From: sally henderson [REDACTED]
Sent: 14 June 2017 22:58
To: Neil Crowther
Subject: Re: COMPLAINT Ref FG 198/16/PL

In the meantime, i have read the officers report on this application and would like to highlight errors and inconsistencies as follows -

JOB: 1 SEA DRIVE, FERRING, WORTHING BN12 5HD
DWG: PROPOSED SITE PLAN

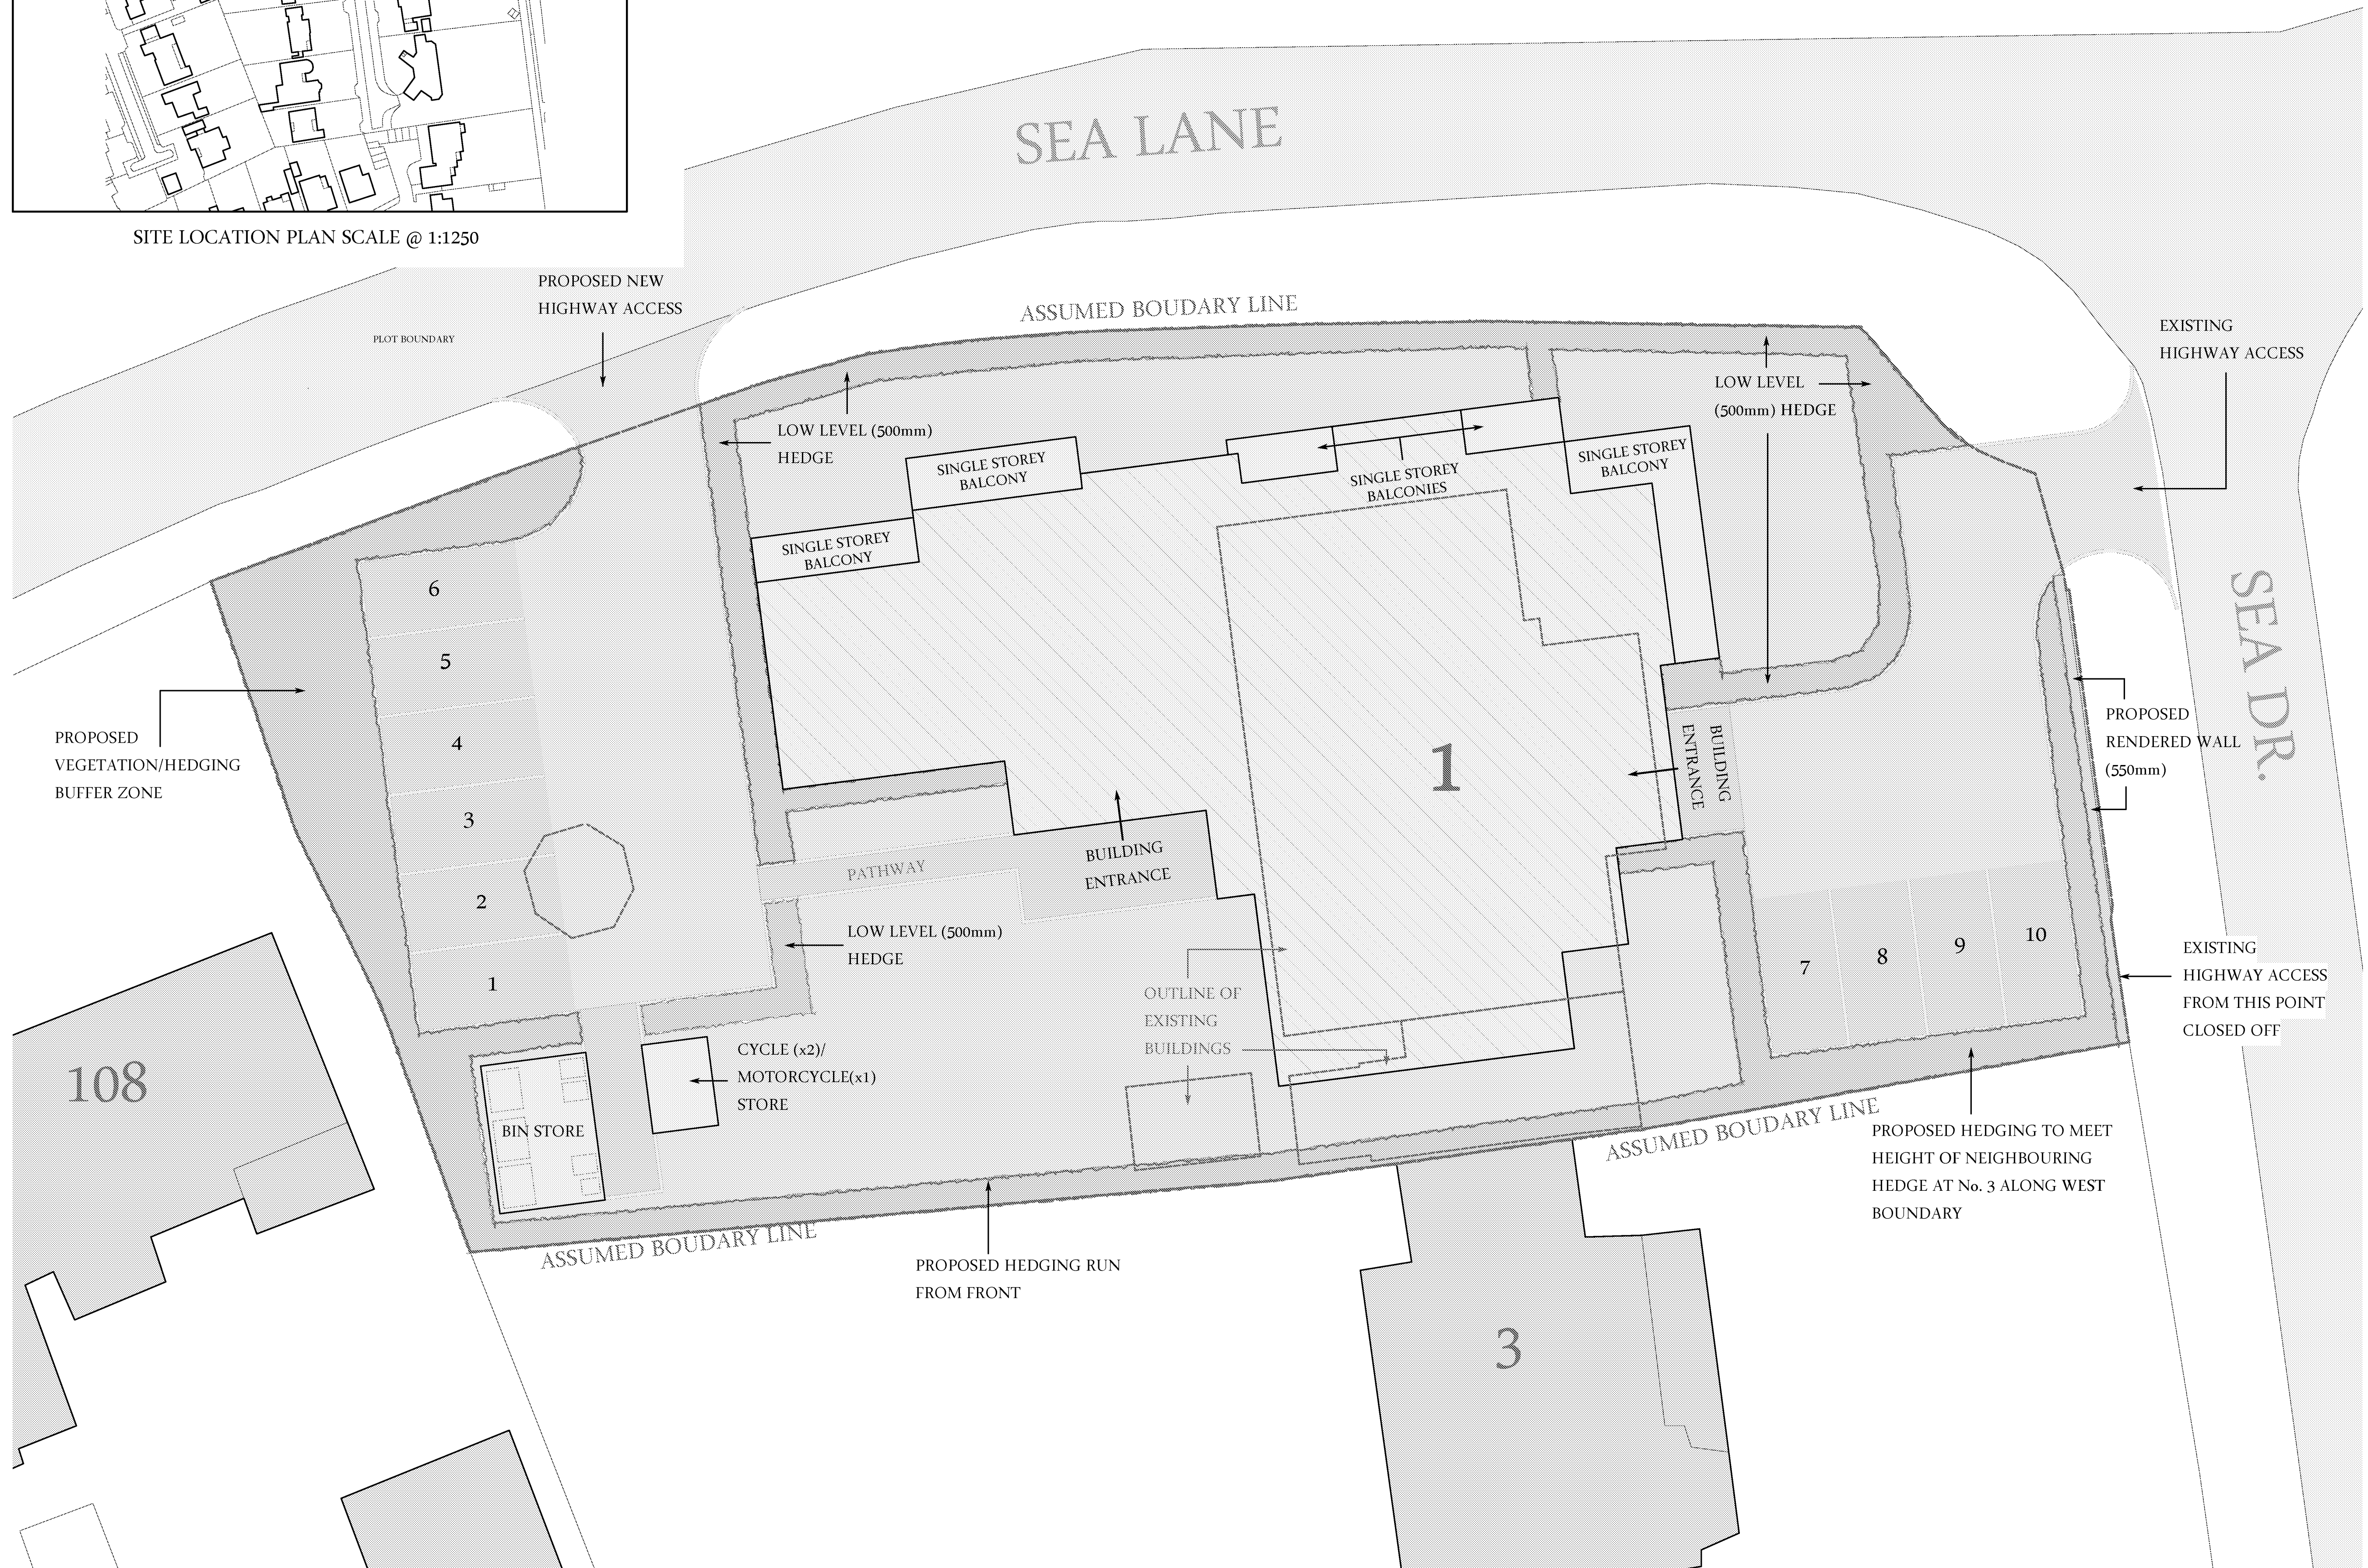
a.) I have attached a scan of the applicant’s site plan revision G, on which i have marked the sight lines from the 2 clear bedroom windows - bearing in mind that overlooking will be able to occur from ground and first floor due to the raised floor levels meaning windows are higher than fence height. It’s clear that these windows can see into the habitable rooms of our home as well as overlook the entirety of our rear garden, even including our courtyard area which is enclosed on 3 sides and where our private hot tub is located.

STREET SCENE SEA DRIVE

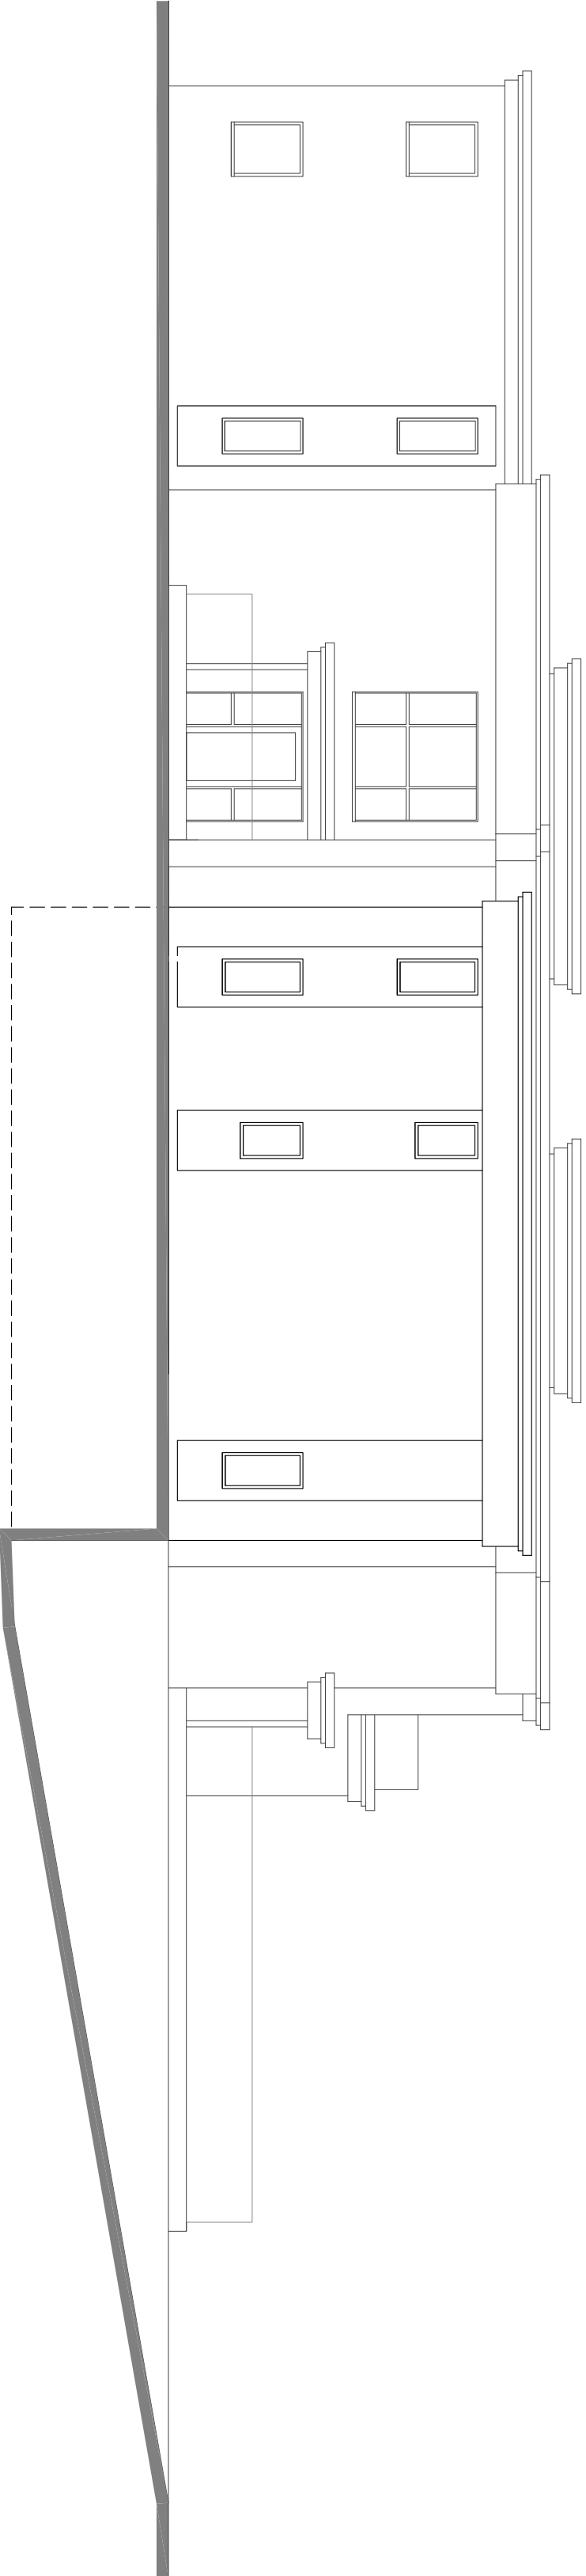
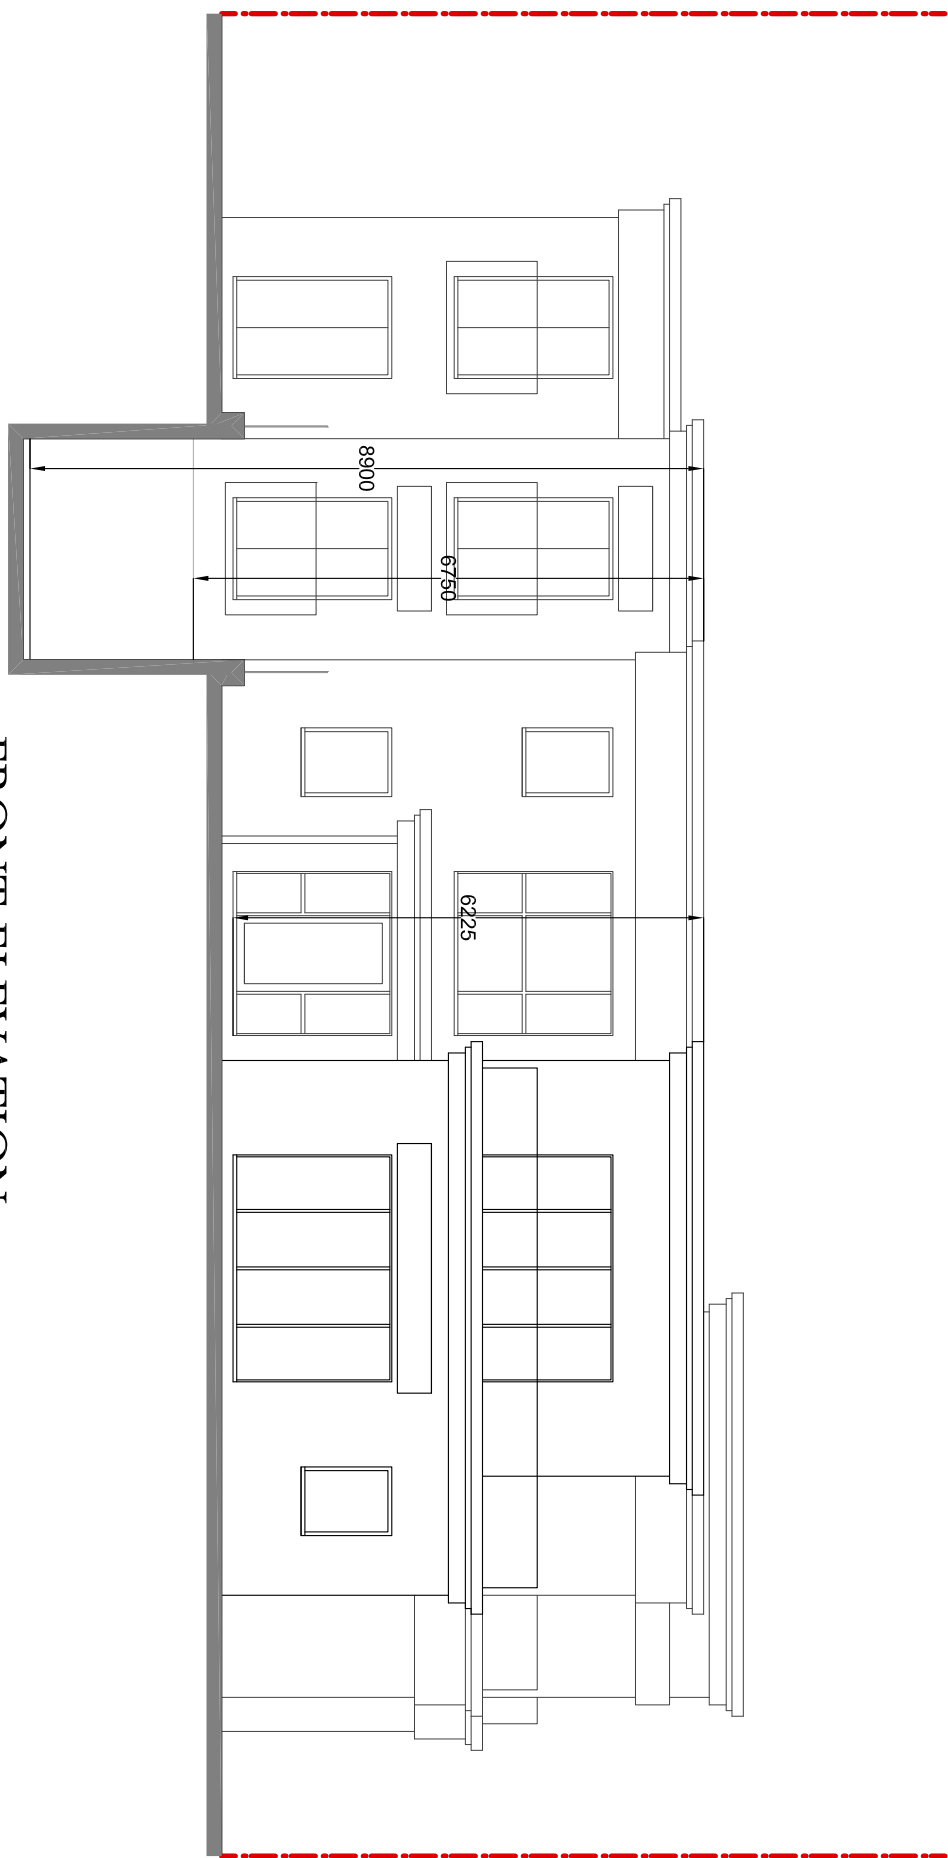
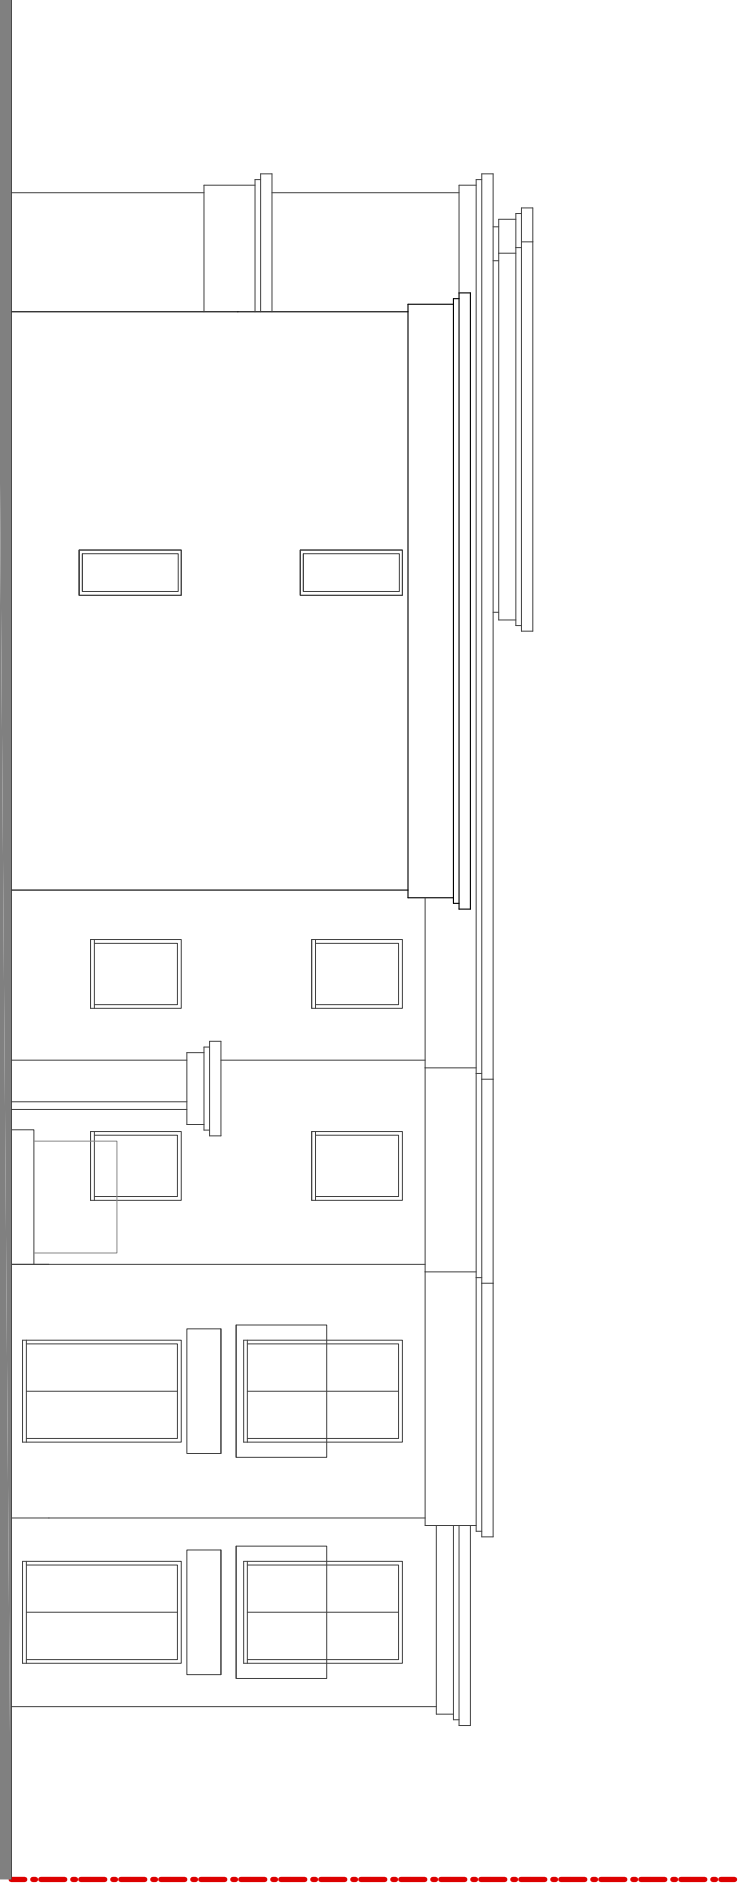
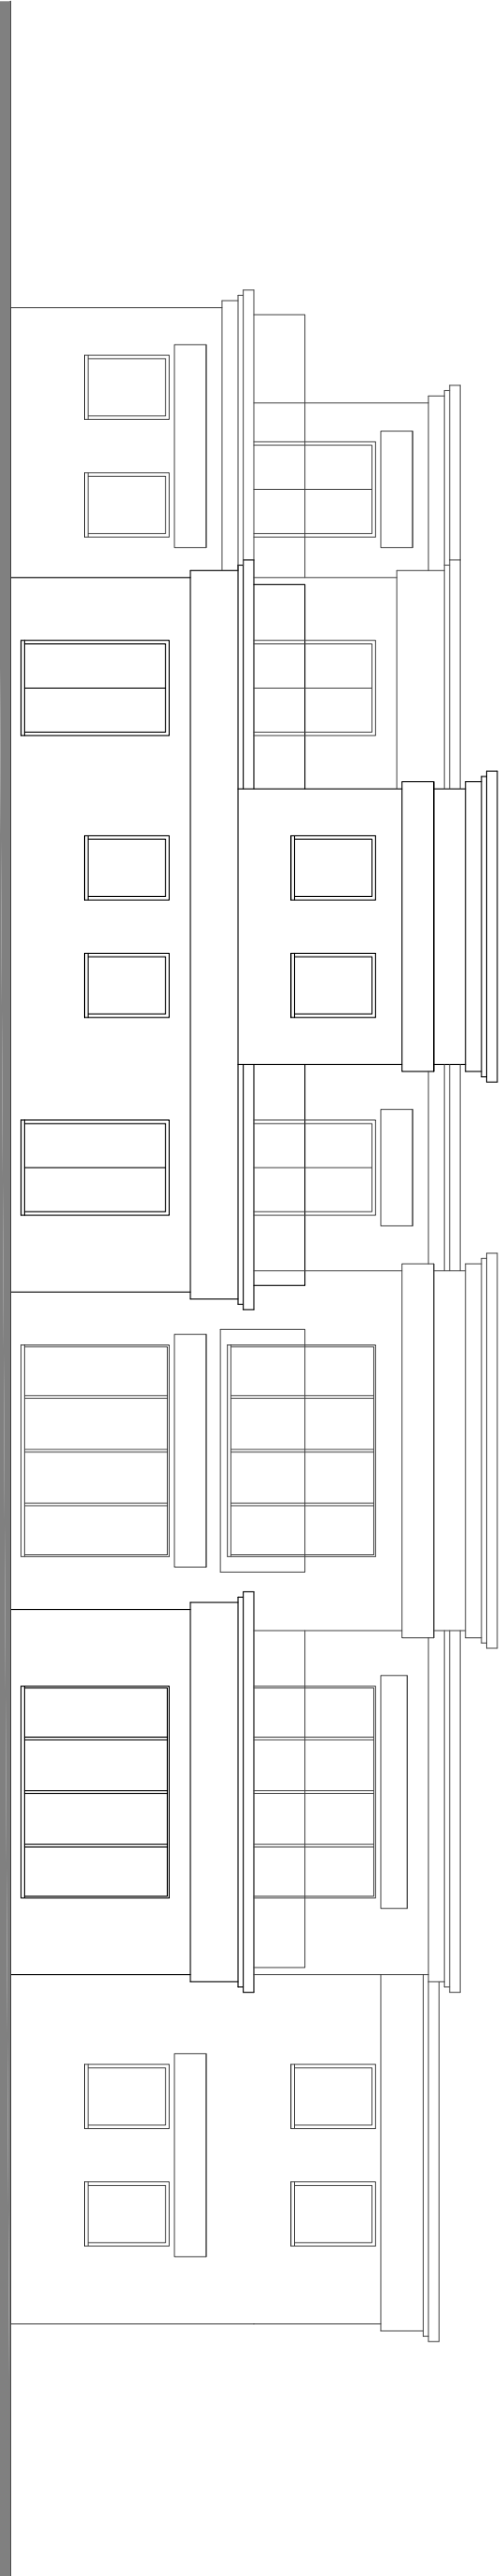
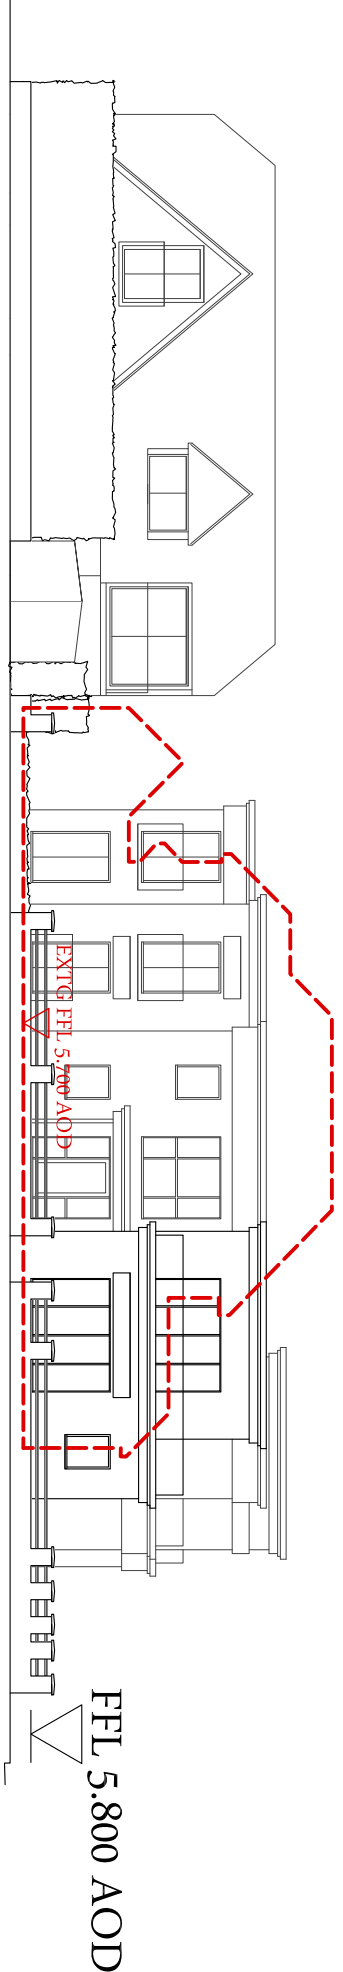
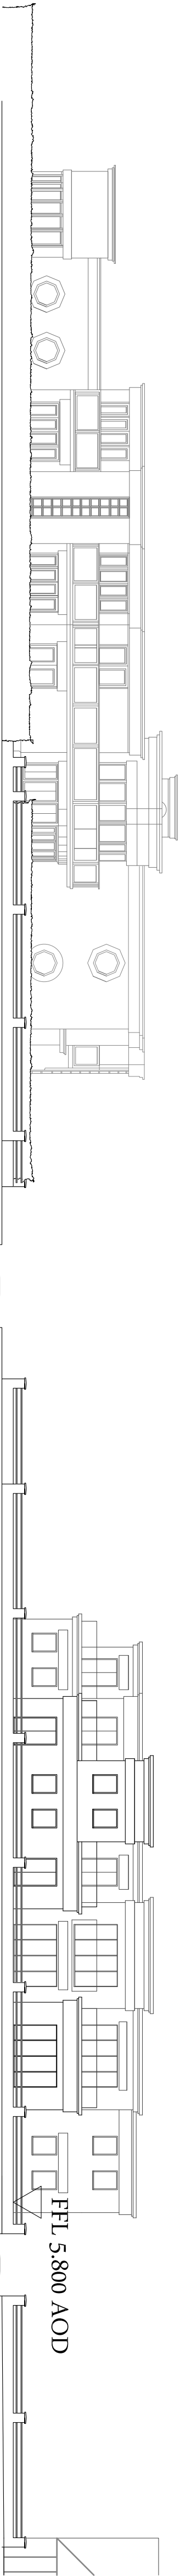
1. **Height of the proposed block of flats** - p 32 of the DCC agenda states that “the development would have a 6.4m maximum height on the front elevation on Sea Drive”. Andrew Woods stated in an email to my neighbour’s son, Jon Gann on 25/4/17 at 10.42, “The substitute elevation plan ‘proposed elevation and street scenes’ drawing no 16/046 PL005 Rev F dated March 2017....does indicate that the height of the building above the car park entrance has risen by 30cm from 6.3metres to 6.6metres.” This email was pasted into my formal complaint text. Should you be in any doubt i can forward it to you again.

What height is it ? Which statement is correct ? This is a hugely important factor in assessing the overbearing impact of the proposal and it simply is totally unacceptable to have these inconsistencies.

2. **Level of Windows** - p.33 states that “the level of the windows shown on street elevations matches that of 3 Sea Drive and would provide an acceptable relationship between the windows and floor levels of the neighbouring property”. It is very clearly shown on the applicant’s most recent street scene drawing 16/046 PL005 Revision G that the level of windows on the proposed flat block are significantly higher than those in our property. The finished floor level is shown as 5.8m AOD, this fact in itself makes it very clear that the windows will of course be correspondingly higher and the drawings confirm that indeed they are.

This is crucial to the extent of overlooking and loss of privacy and the facts have been stated incorrectly in the report which means the assumptions and conclusions are also incorrect - what will be done to rectify this mammoth mistake ?
